June 1, 2022

Attention: Jeremiah Cromie, Planner

Subject: LPF-22-00003, Blue Jay Land Co.  
SR 903 MP 8.11 right, Rock Rose Drive

WINTERFALL AT ROSLYN RIDGE

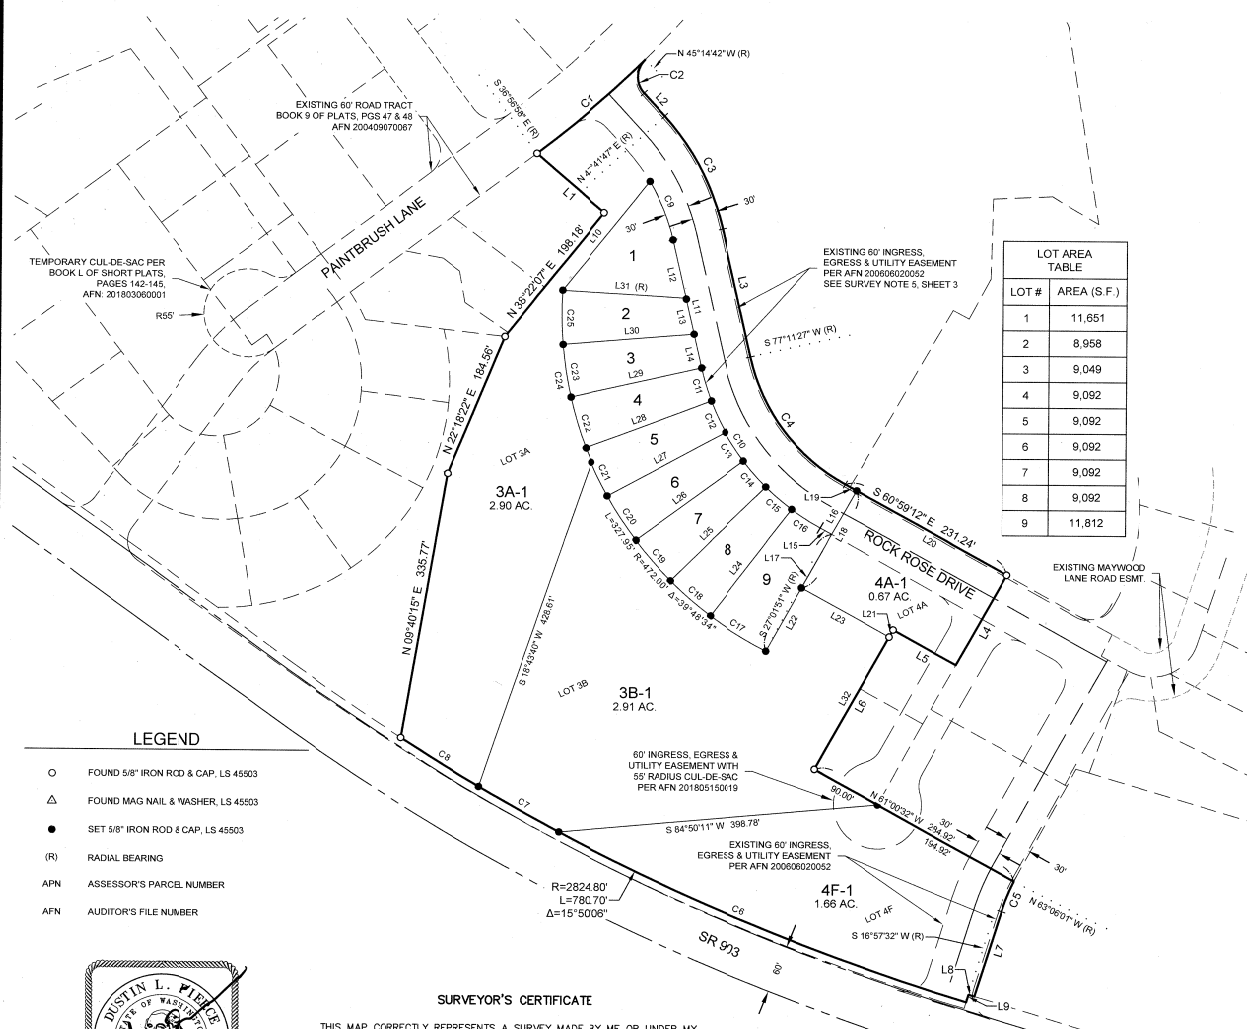
- The subject property is adjacent to State Route 903 (SR 903), a Managed Access Class 4 highway with a posted speed limit of 45 miles per hour. Access to the subject property is currently via the existing permitted private road Rock Rose Drive. No new access to SR 903 will be allowed. We require a restrictive note be put on the plat indicating direct access to SR 903 will not be allowed for Lot 3A-1, Lot 3B-1 and 4F-1.
